December 14, 2019

RE: Bent Grass Residential Filing No. 2 – Pre-Development Grading  
Response to “Bent Grass EGP” Comments

INTERIM GRADING & EROSION CONTROL PLAN

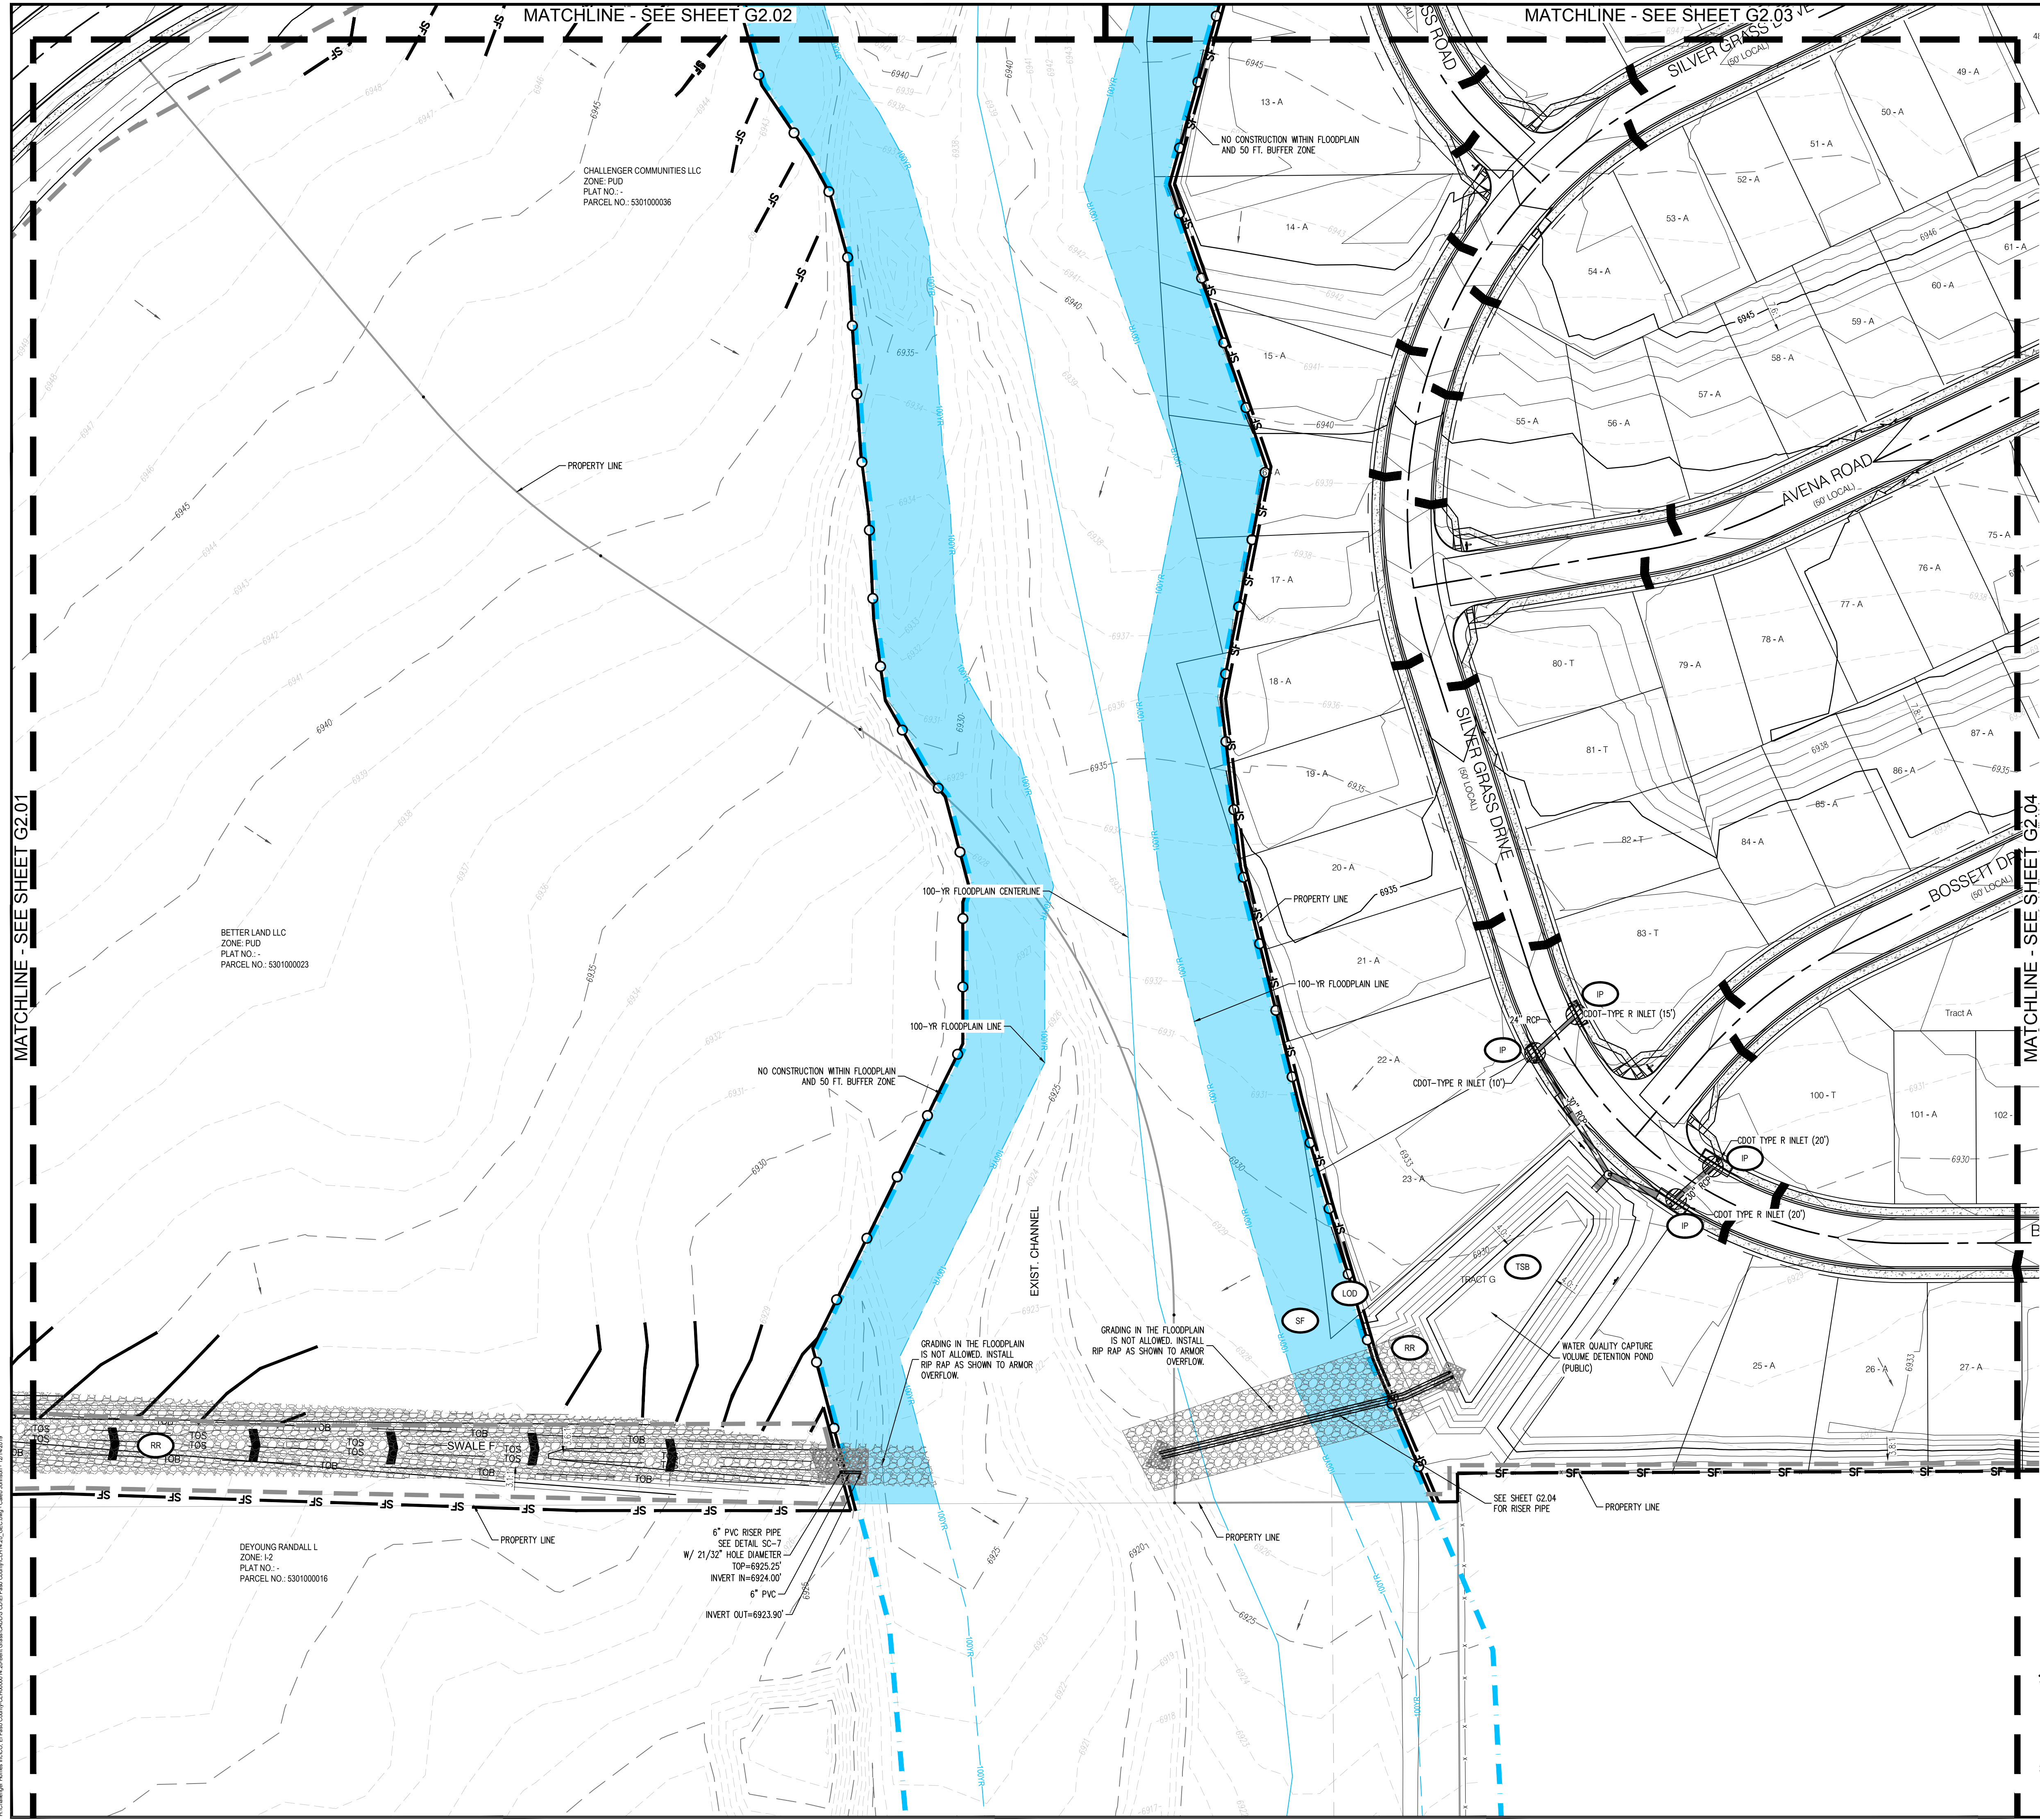
1. There is questionable grading at the interface between the floodplain and the proposed grading that comes up to the designated “no construction area” where I see things like a channel (or pond) graded in and it just stops a foot short of the construction fencing. This will create ponding that I do not think you have the water rights to create a pond without an outfall. This is the major item of concern with the resubmittal. This appears to happen at five locations, please correct me if I am wrong. Please address this issue.

**Response: Our intention was to have the overall development plans approved quickly which would allow the entire development to be graded and avoid any ponding issues. To address this concern, we included 6” PVC pipe from each low area into the existing channel. These pipes are designed based on the “Sediment Basin (SB), SC-7” detail and include a pipe along with a riser. In addition, rip rap was added to the overflow areas for armor against erosion. A note was added to the plans indicating no grading is allowed in the Floodplain, only installation of the rip rap and 6” PVC pipe.**
